Your ref Y/15/11

Change of use from (C3) dwelling to (D1) day nursery Longacre Bungalow, Maypole Lane, Yapton.

Proposed First Floor Plan

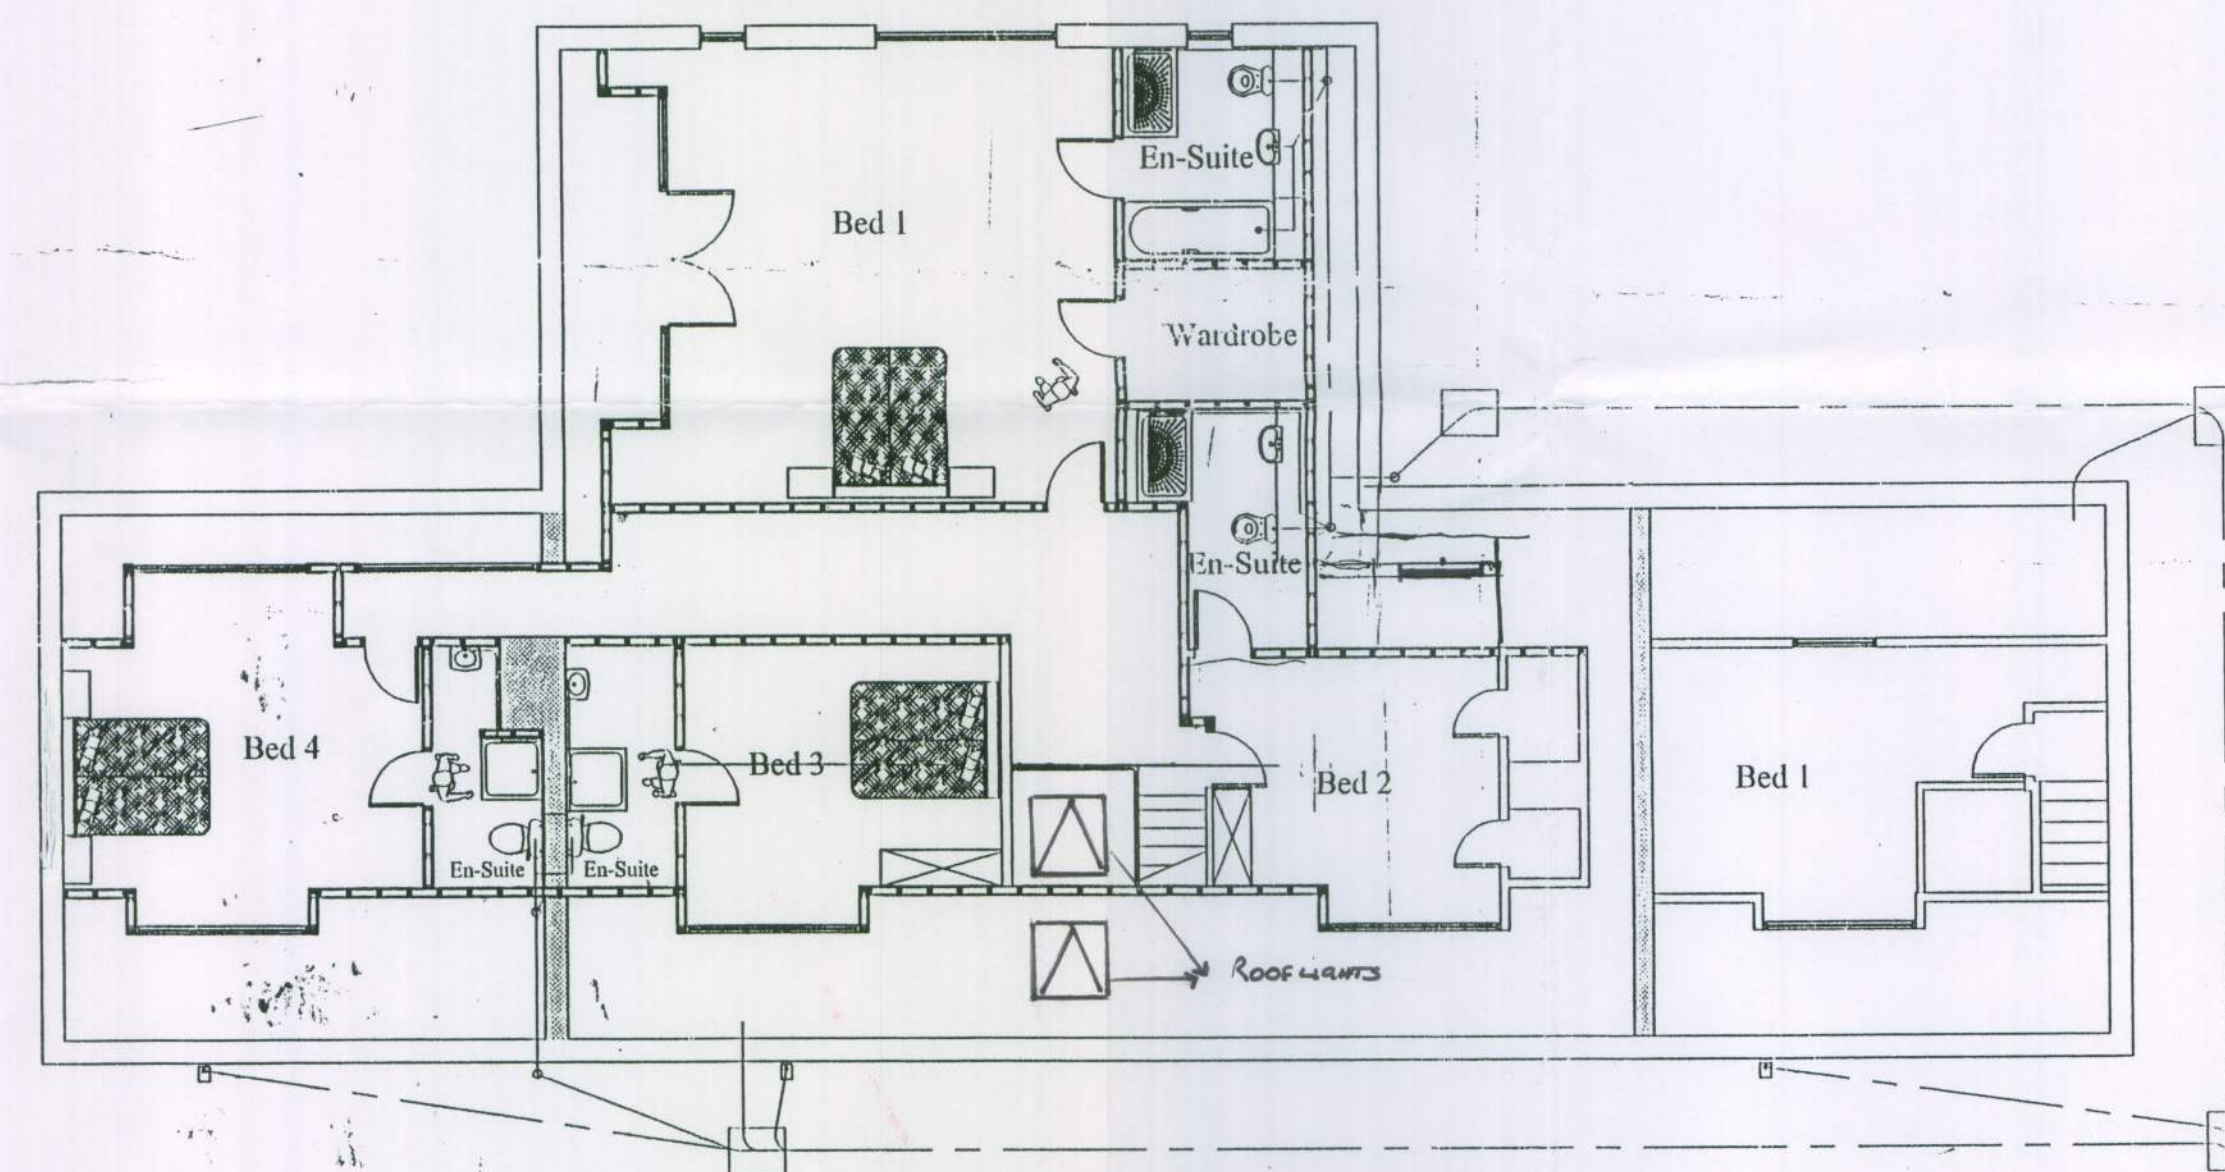
The window shown on the first floor plan (Bed 1) has been omitted on the drawing but was in the original submitted elevation drawing so in this instance the elevation drawing is incorrect and the first floor plan is correct.

Proposed North Elevation

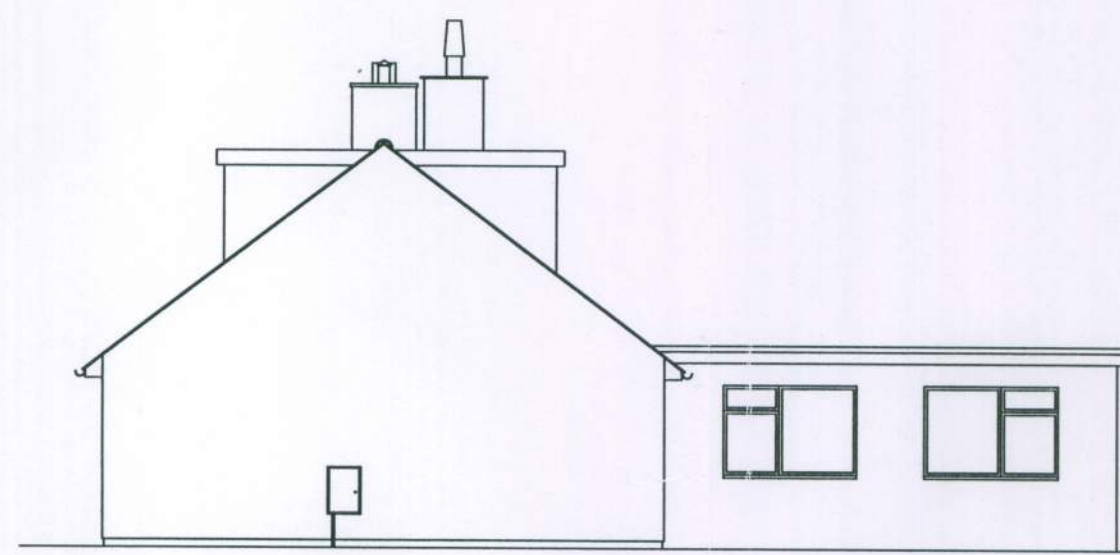
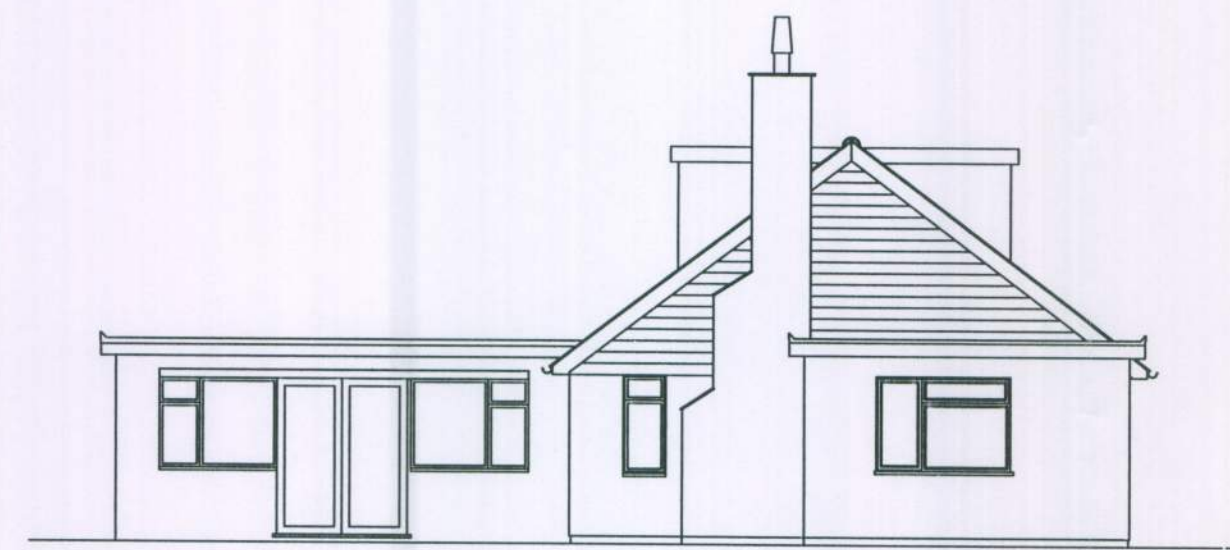
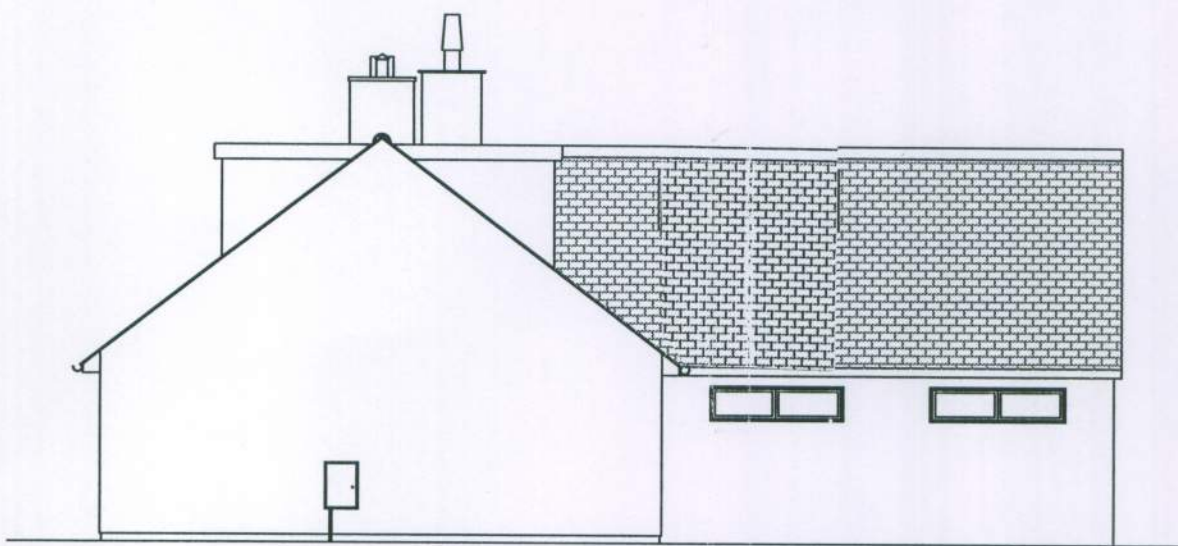
I can confirm that the 2 rooflights shown on the north elevation were omitted and therefore are not shown on the floor plan. They were not installed and this can be confirmed by a site visit if necessary.

Proposed East Elevation

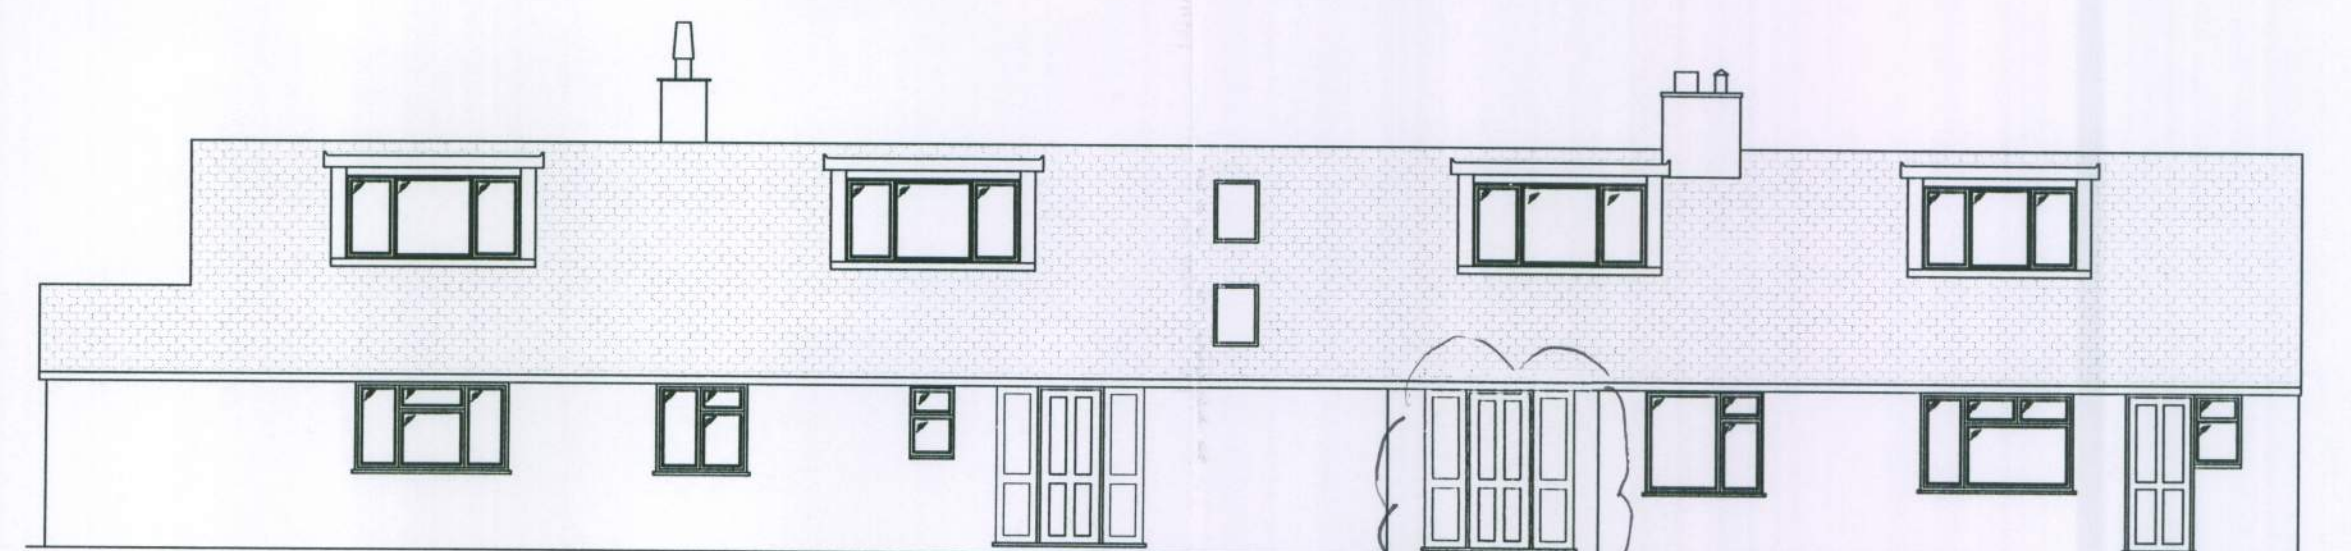
The two windows shown to the left on the East elevation: The elevation drawing is correct and the ground floor plan is incorrect. (I am assuming the '2 rooflights which are not shown on the first floor plan' are the 2 previously referenced above.)

Proposed West Elevation

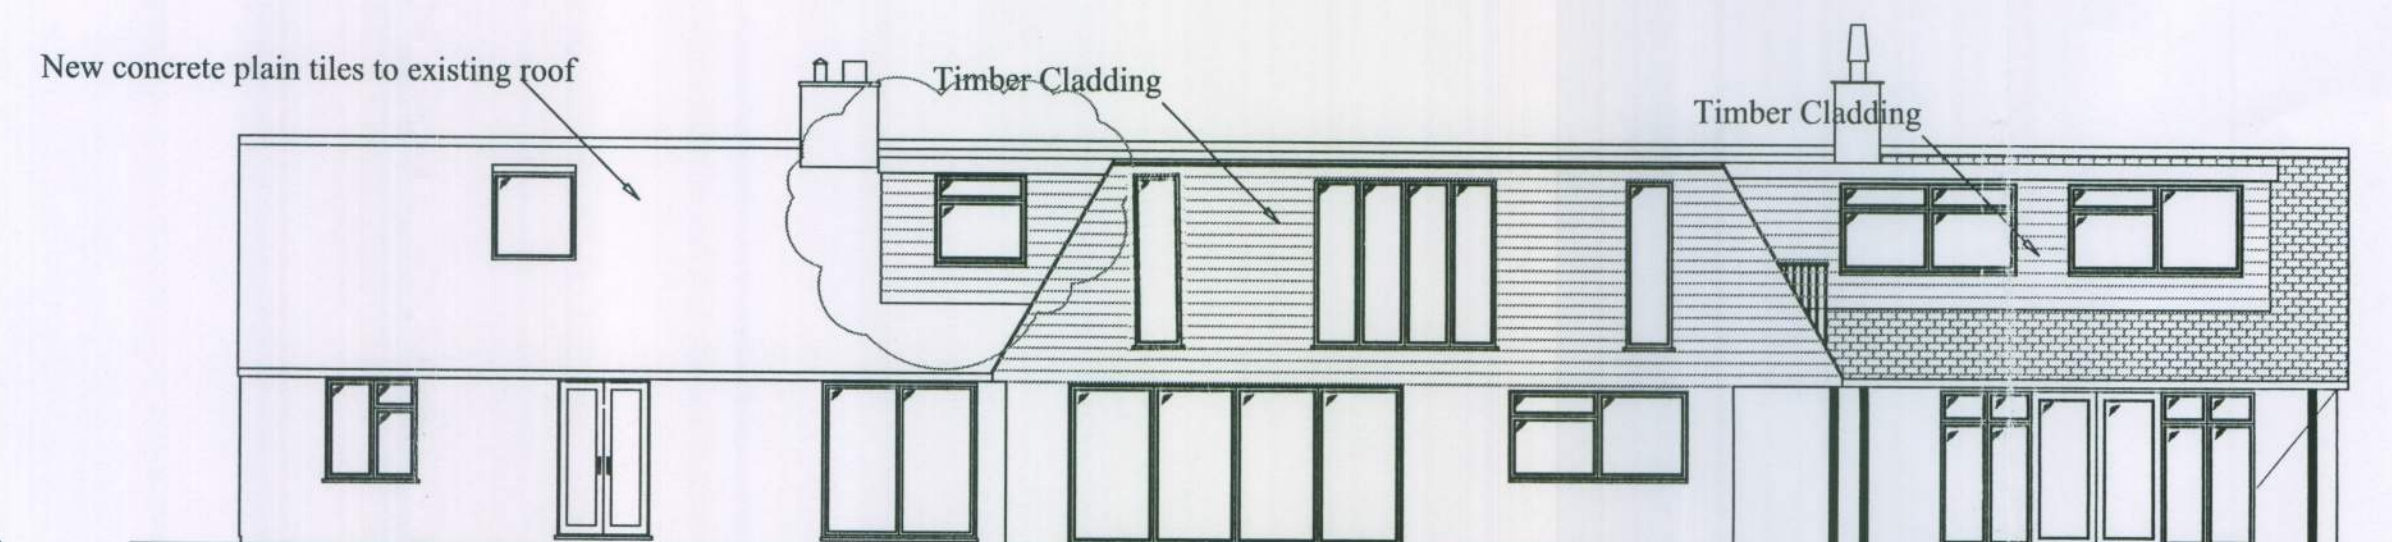
The second window from the left on the west elevation highlighted in a bubble was an amendment to the planning application for the extension and was not shown on the plan. The amendment was approved. In this instance the West elevation drawing is correct.
